Mr Leigh Cook - Project Director
Pacific National
Level 16 15 Blue St
NORTH SYDNEY New South Wales 2060
08/07/2019

St Marys Intermodal (SSD-7308)
Response to Submissions

Supplementary Key issues

FIGURE 19 EXHIBITED – STORMWATER LAYOUT - PHASE 1

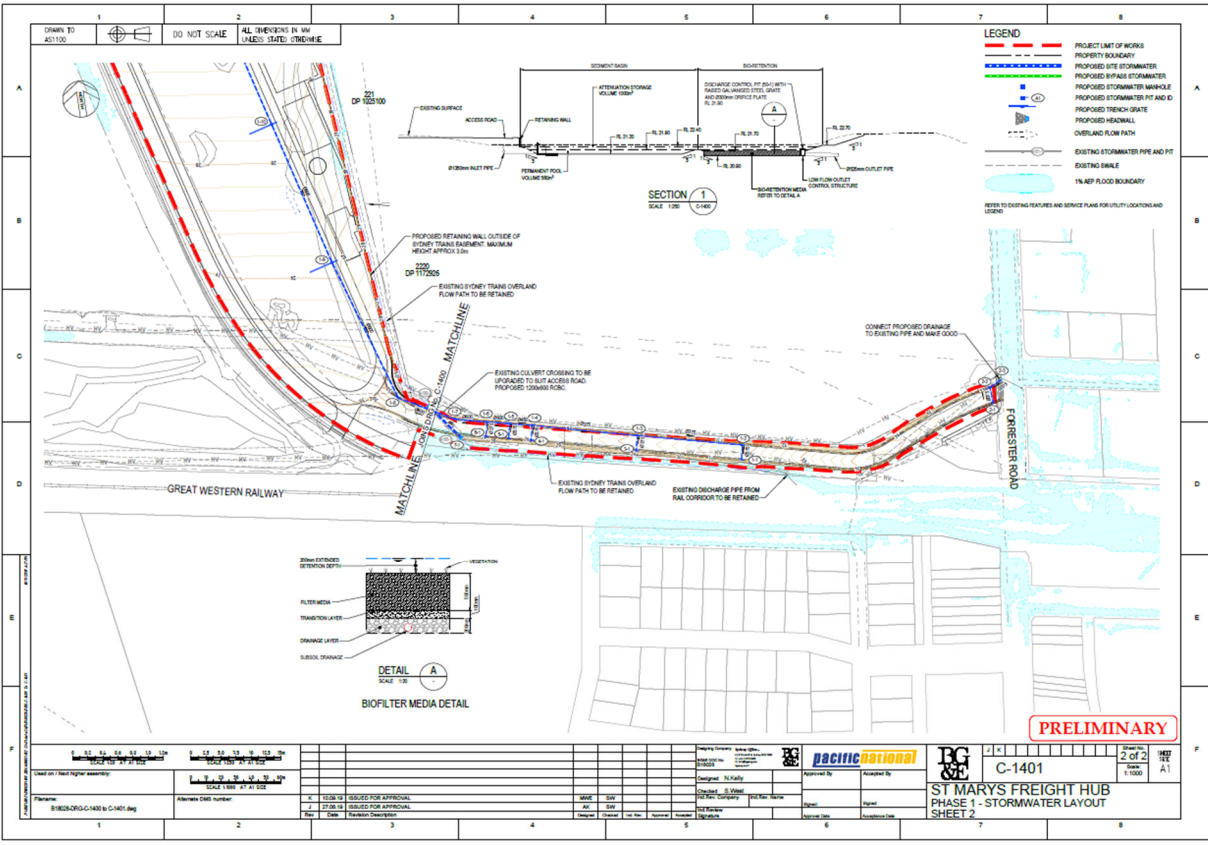
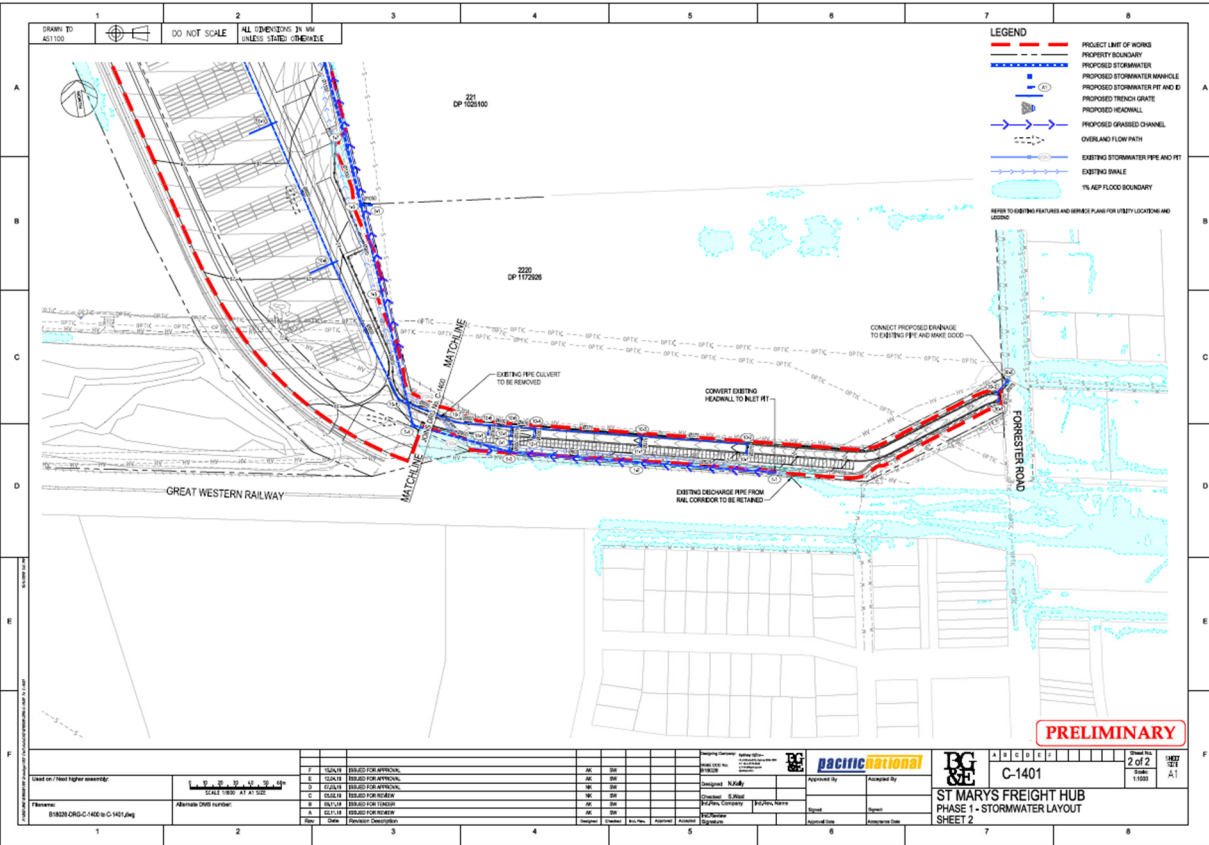
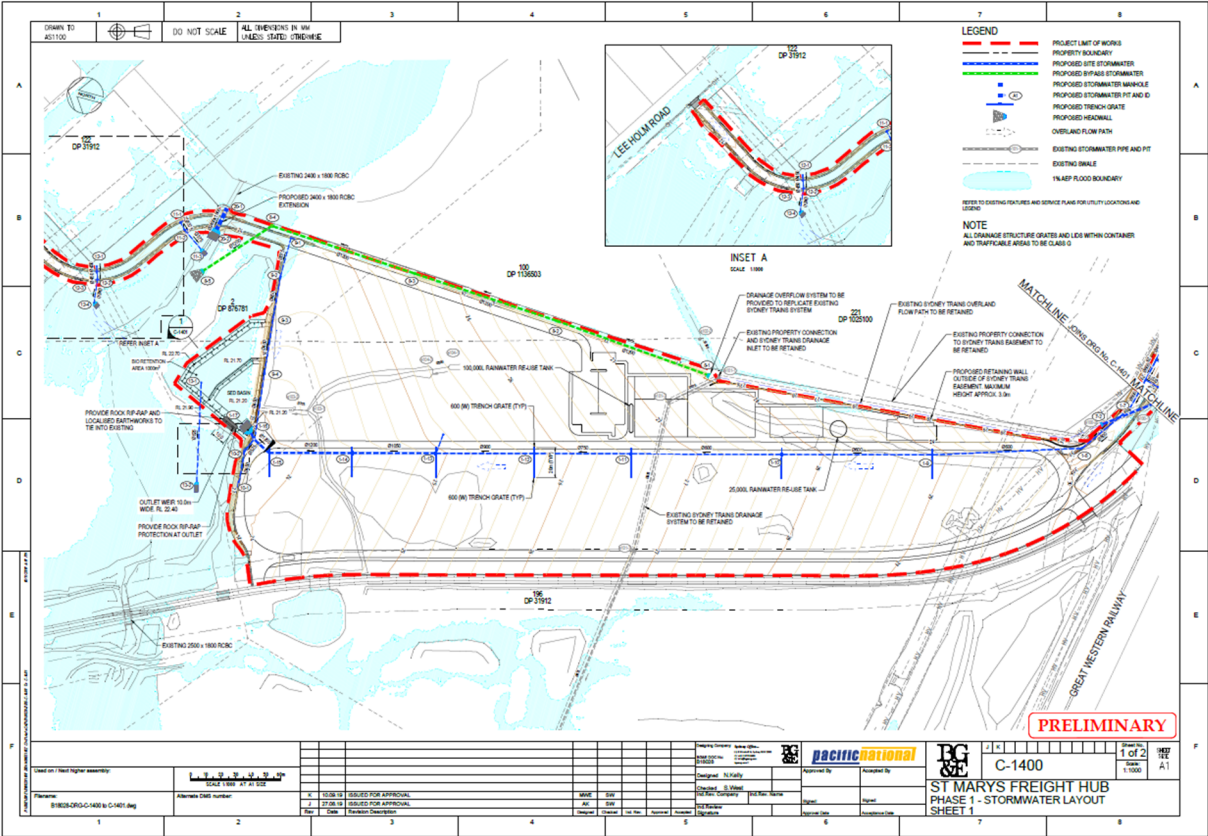
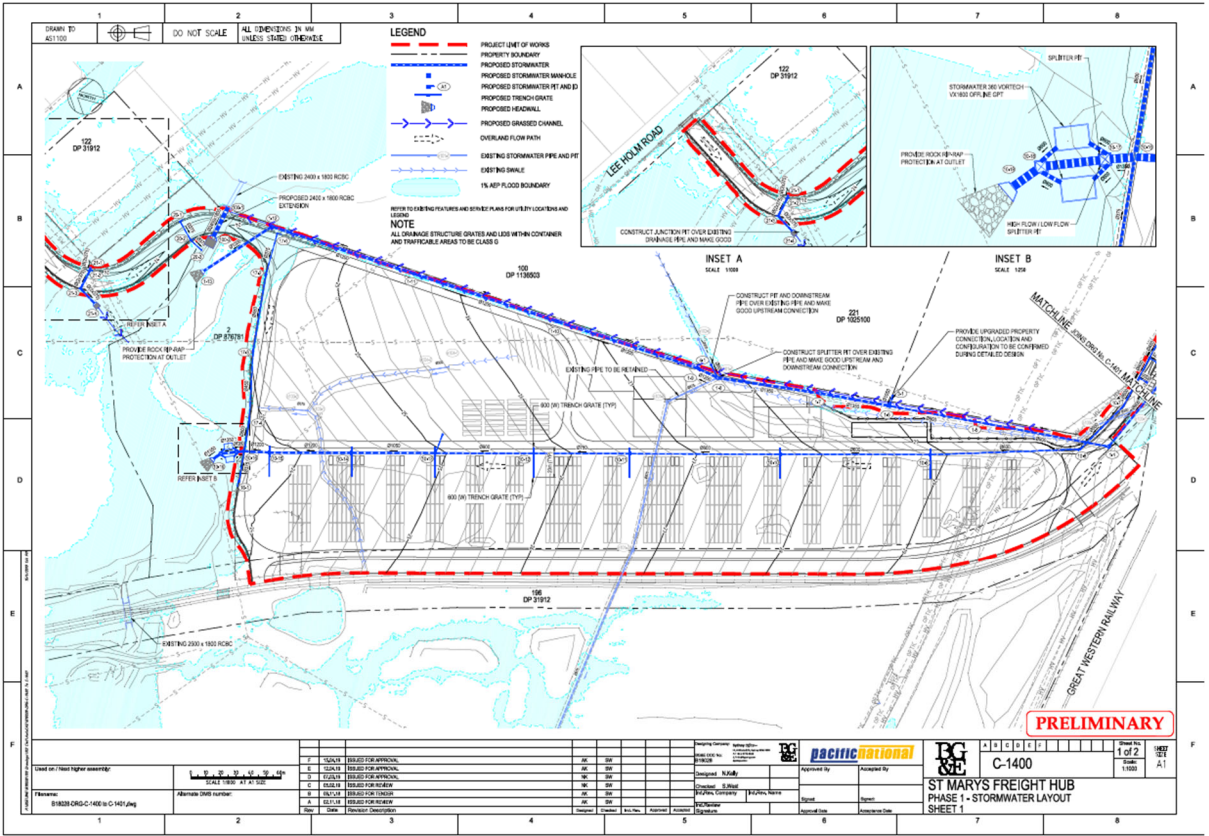
- Provision of a detailed water balance for the site in accordance with the SEARs for the project.
 - The Submissions Report must respond to Penrith Council and the EPA concerns in relation to construction management of stormwater runoff, particularly with regard to *Managing Urban Stormwater, Soils and Construction Volumes 1 and 2* and in relation to the existing stormwater basins.

FIGURE 23 EXHIBITED – FLOODING IMPACT ASSESSMENT

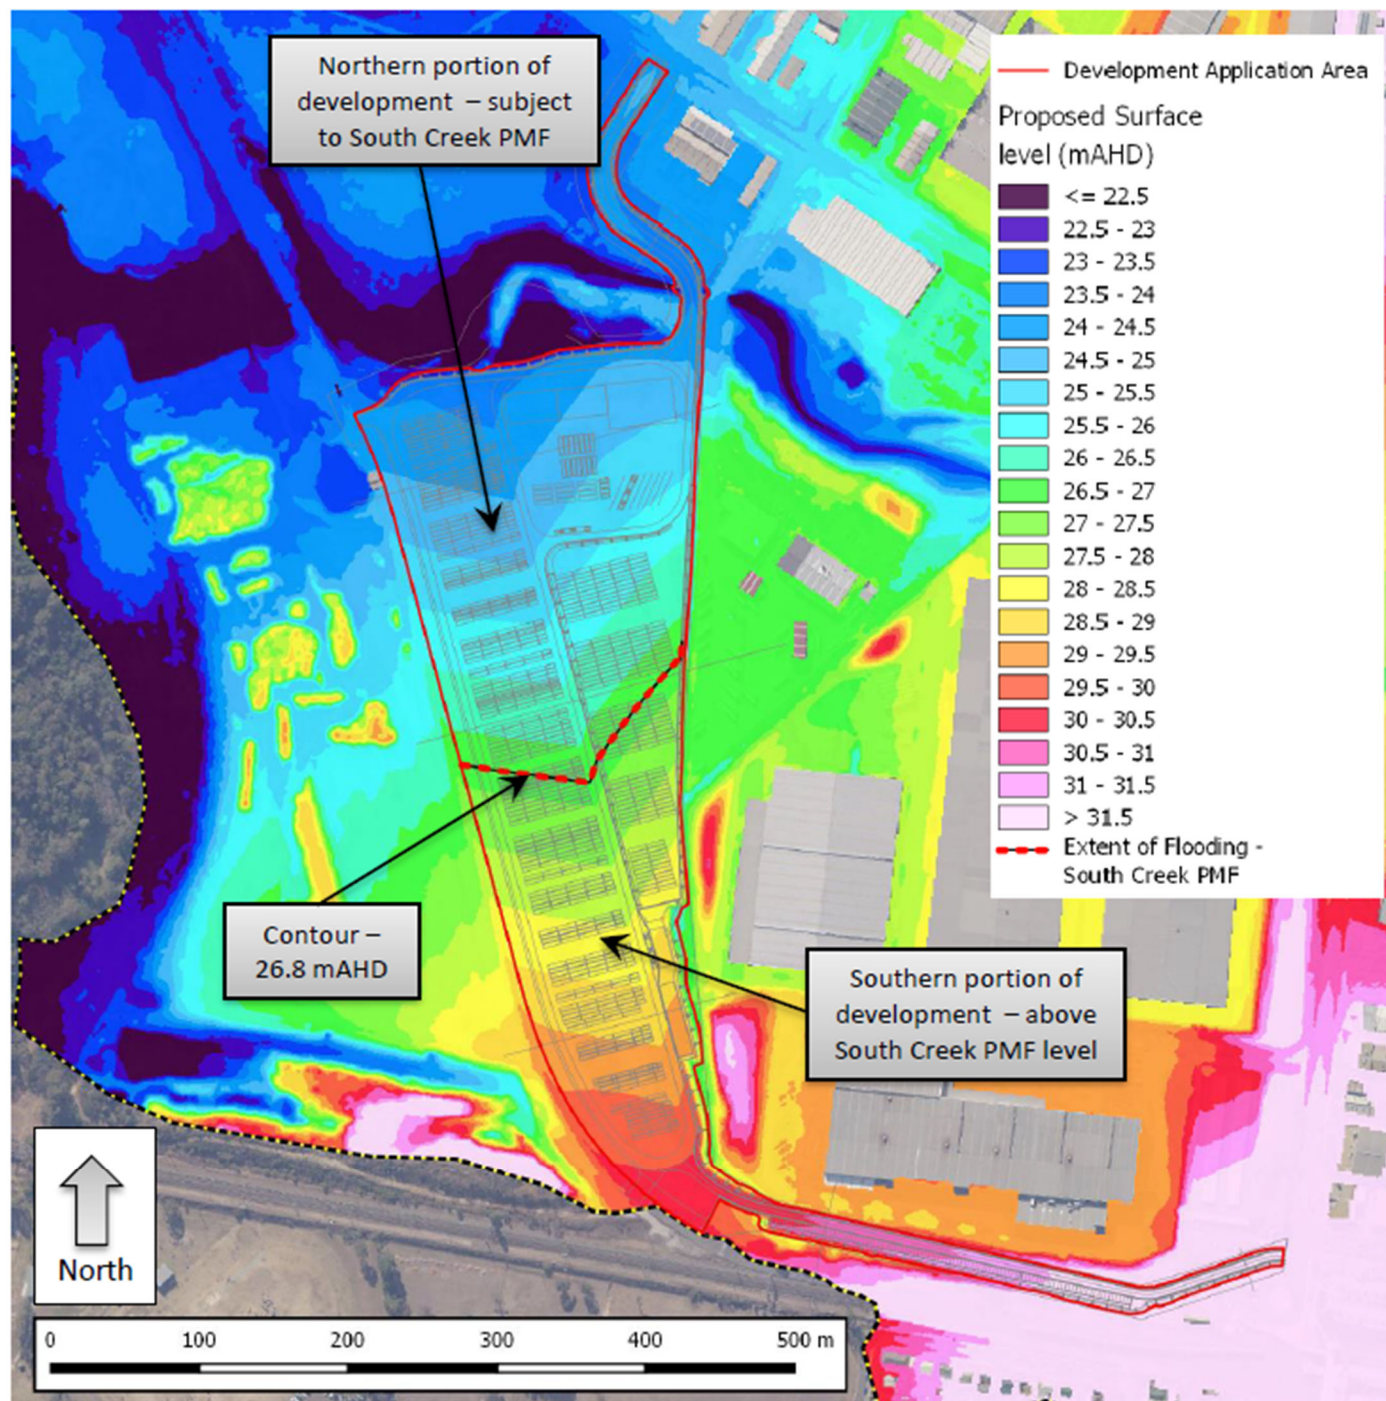
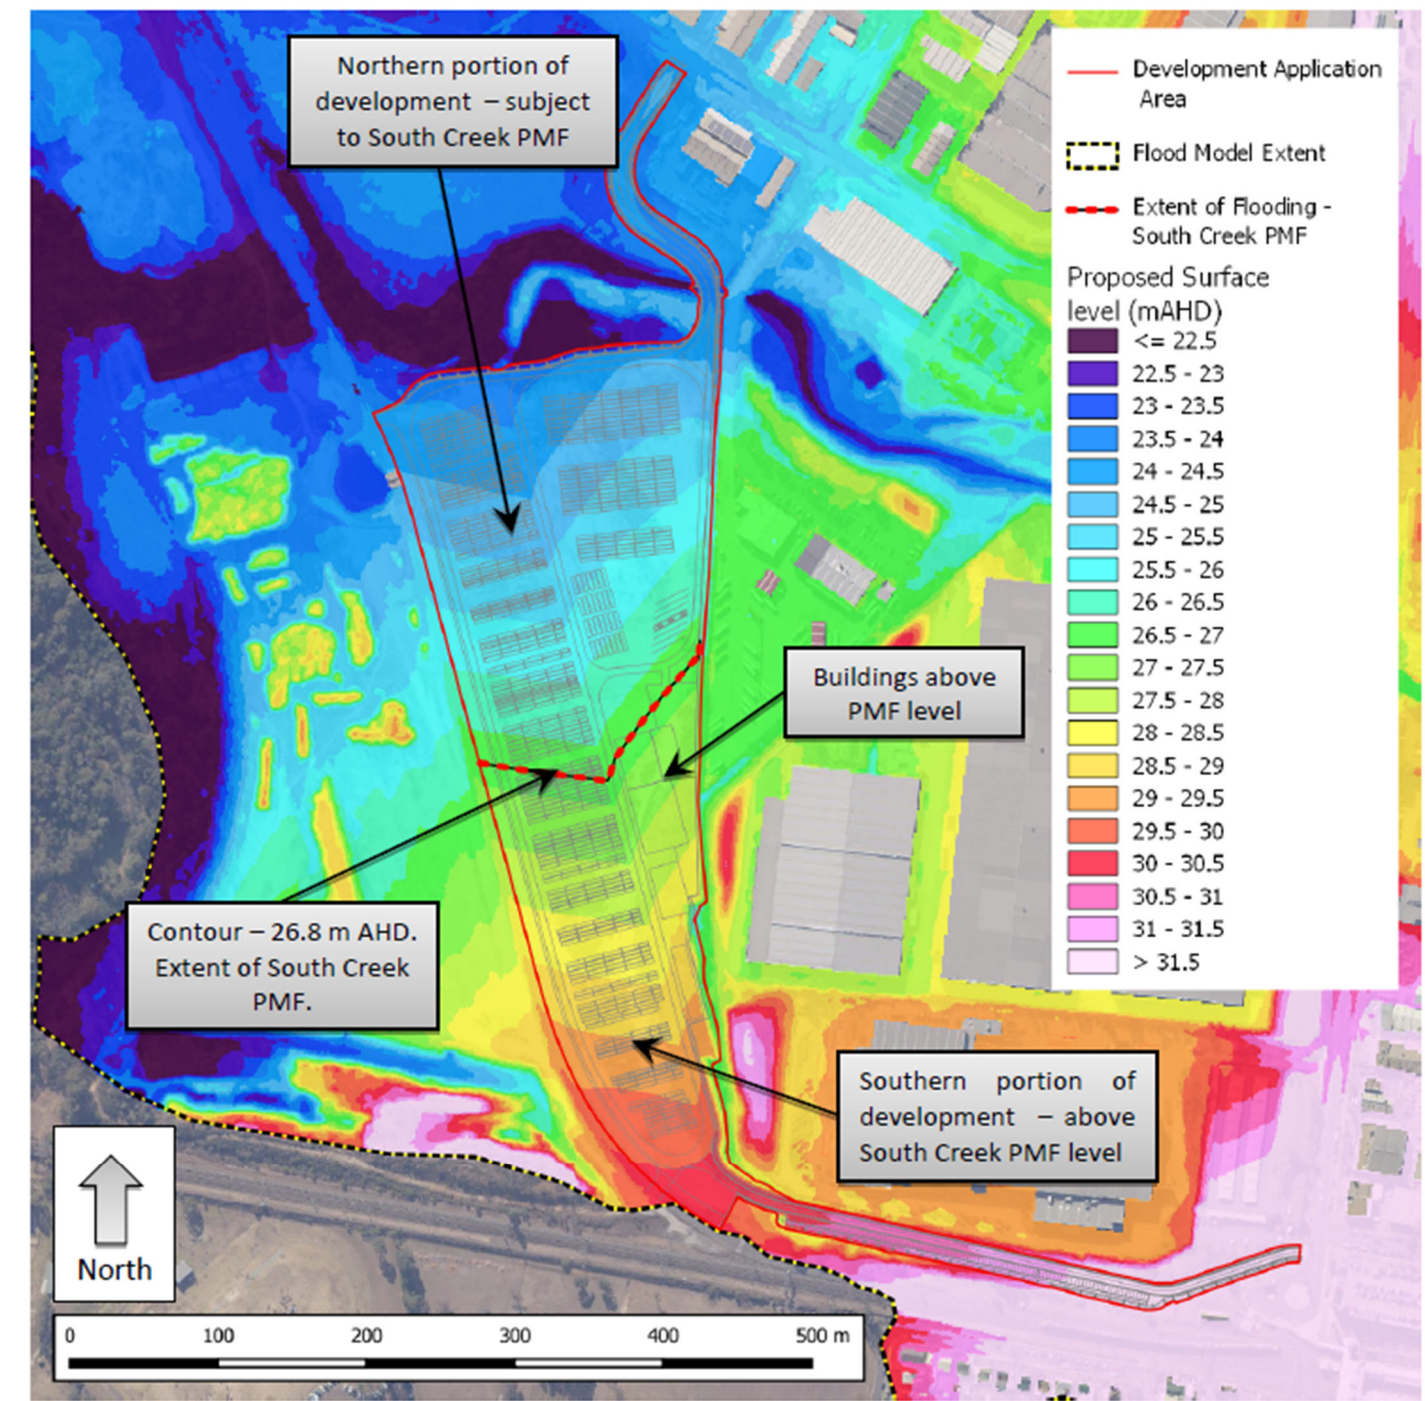
- The Department notes concerns raised by Penrith Council in relation to the modelling of hydrological and flooding impacts. The Submissions Report must address modelling constraints deferred in the EIS to detailed design, including consideration of the *NSW Government Floodplains Development Manual*, the *Local Environment Plan* and Council's *Development Control Plan for Flood Liable Lands*.

FIGURE 31 TRUCK ROUTE - OPTION 1

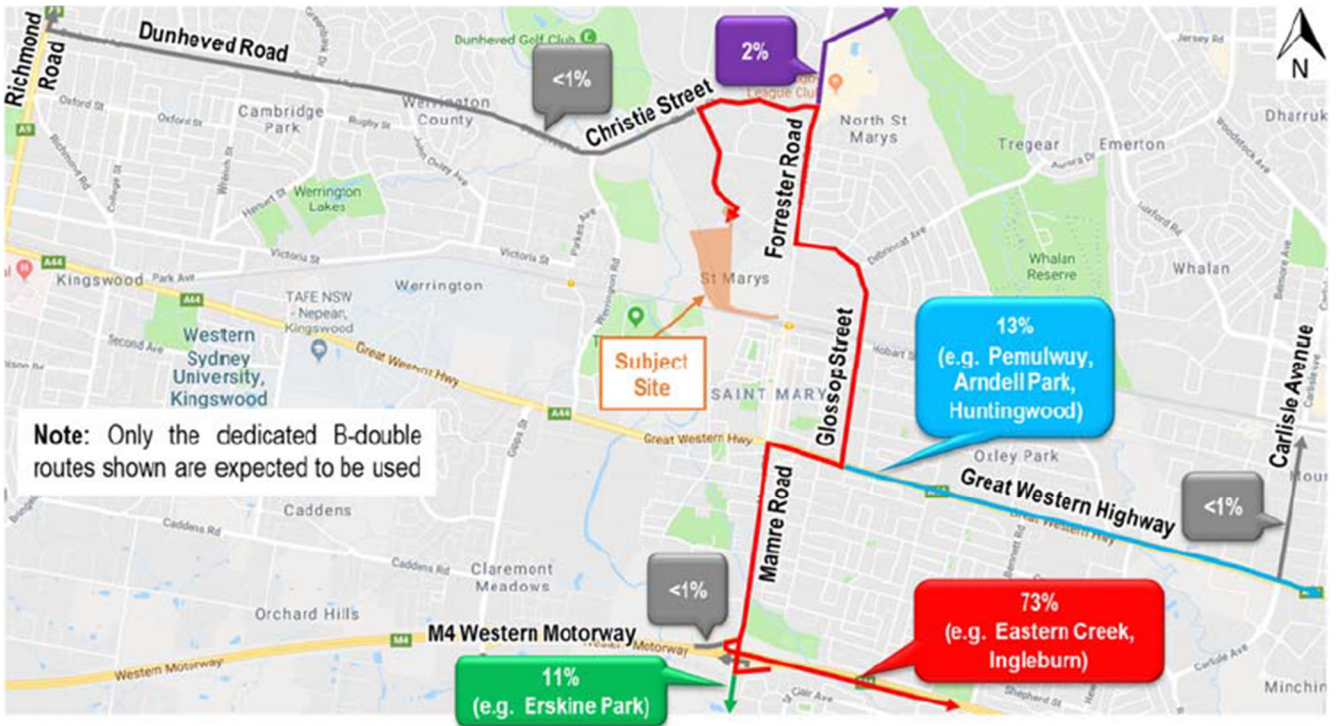
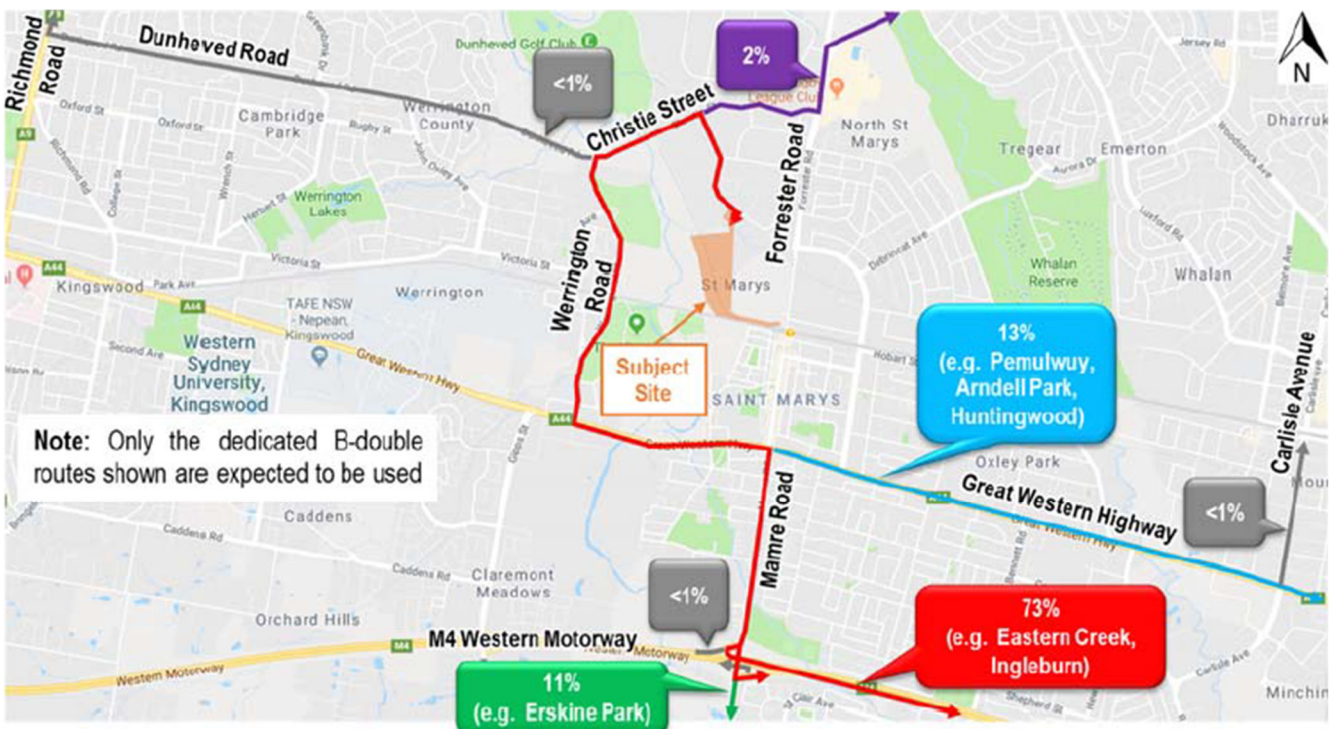
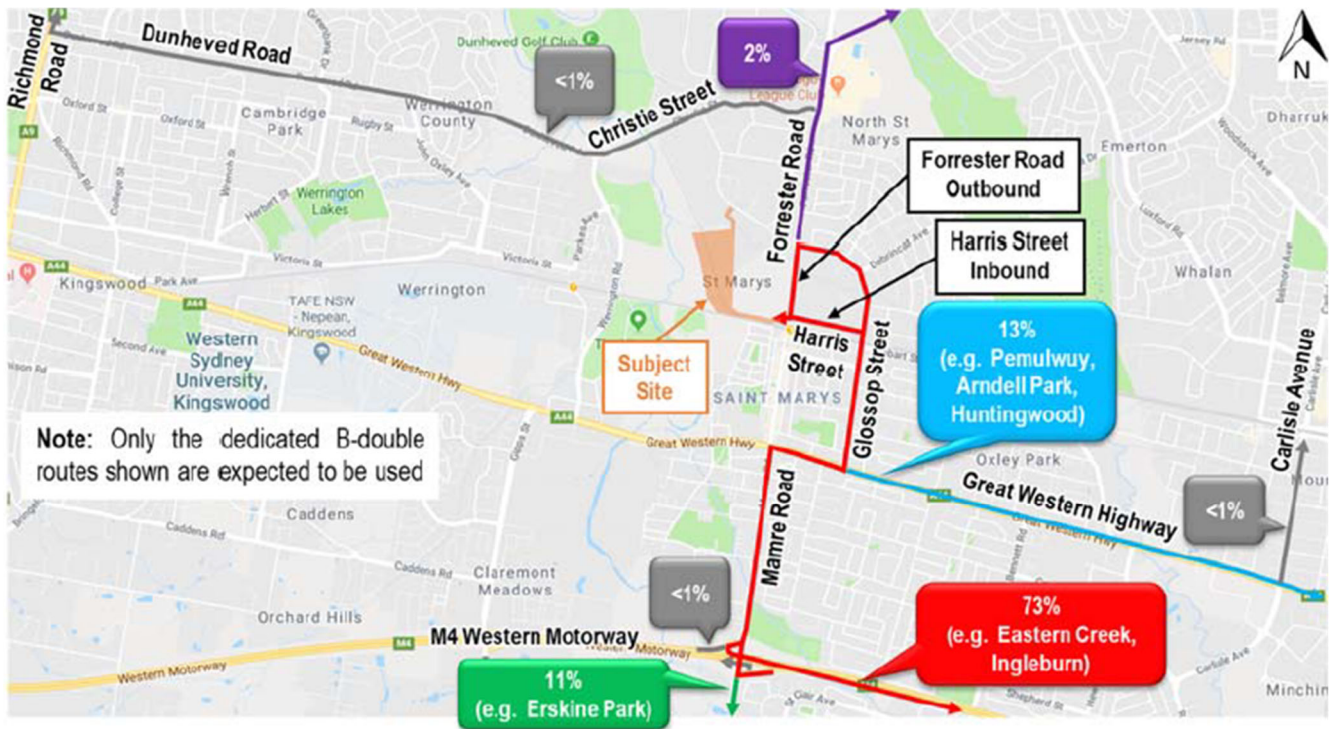
- Lee Holm Drive/Christie Street
 - Christie Street/Forrester Road
 - Forrester Road/Glossop Street
 - Dunheved Road / Christie Street
- The Department notes Council's concerns regarding the proposed haul routes to and from the M4 Western Motorway. As part of your response, please outline available options for heavy vehicle access from the site to the arterial road network, and an assessment of each option.

- The Department has concerns about the use of Lee Holm Road and, in particular, the suitability of that road to accommodate two-way truck movements and safe access and egress from the proposed site access at an intensity proposed by the development. Please consider and assess if road widening is required to ensure a safe and operable standard is maintained along Lee Holm Road.
